Development Facilitation Team (DFT) – Review Comments

Project No: PR-2020-004024

Request: Create 4 new lots from 3 existing lots, vacate a portion of single Easement [20], and Grant Public Utility Easement.

Application For: SD-2024-00074 – PRELIMINARY/FINAL/PLAT (DHO)

Plat
for
**Tracts H-5A-1, H-6B-1,
H-6B-2, and H-9A-1**
Ventana Square at Ventana Ranch
Being Comprised of
Tracts H-5A, H-6B and H-9A
Ventana Square at Ventana Ranch
City of Albuquerque, Bernalillo County, New Mexico
October 2023

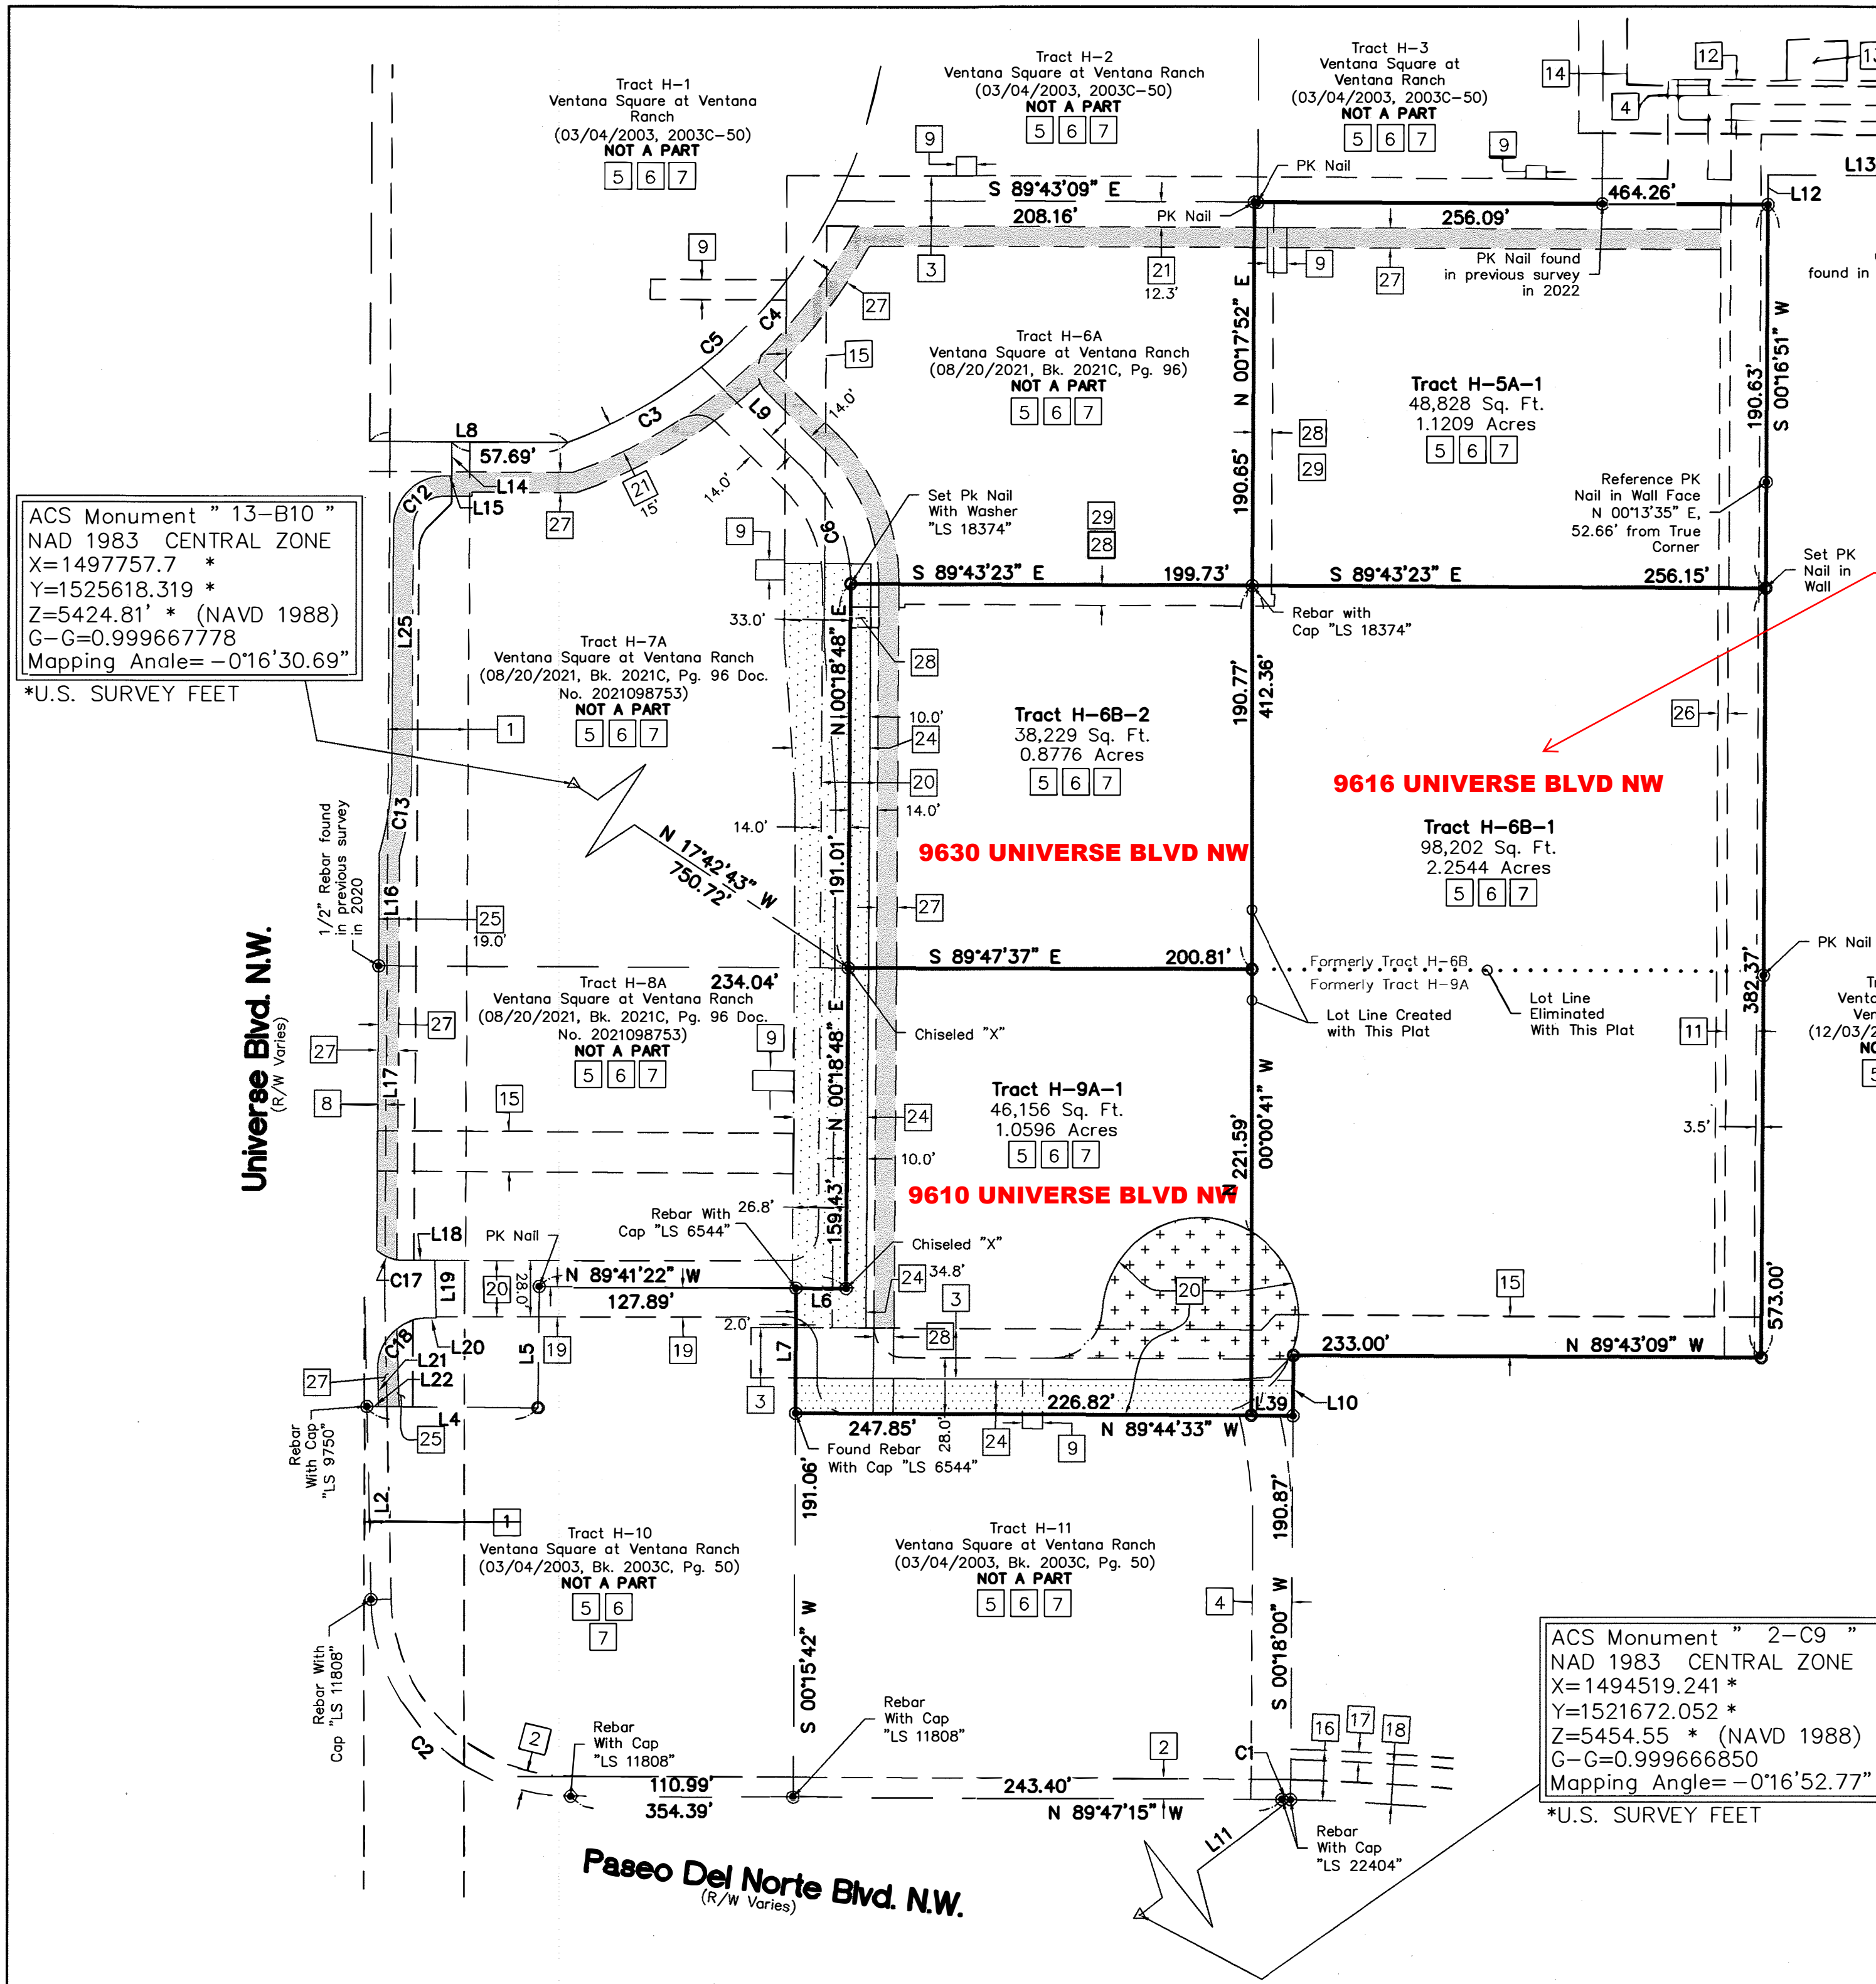
a. Please add the following note to the plat:

- i. “Existing public water and/or sanitary sewer infrastructure may not be constructed or sized to adequately serve potential future development. Improvement or upsizing of existing public infrastructure may be required as a condition of future development approval.”

b. Please dimension easement 24 in the note.

c. Easement 15 appears to have linework that is not showing on the Southeast portion of the platted area. Please ensure this is visible and clearly identified.

2. Add the following note on the plat when easements are being granted for public water and/or public sanitary sewer infrastructure.
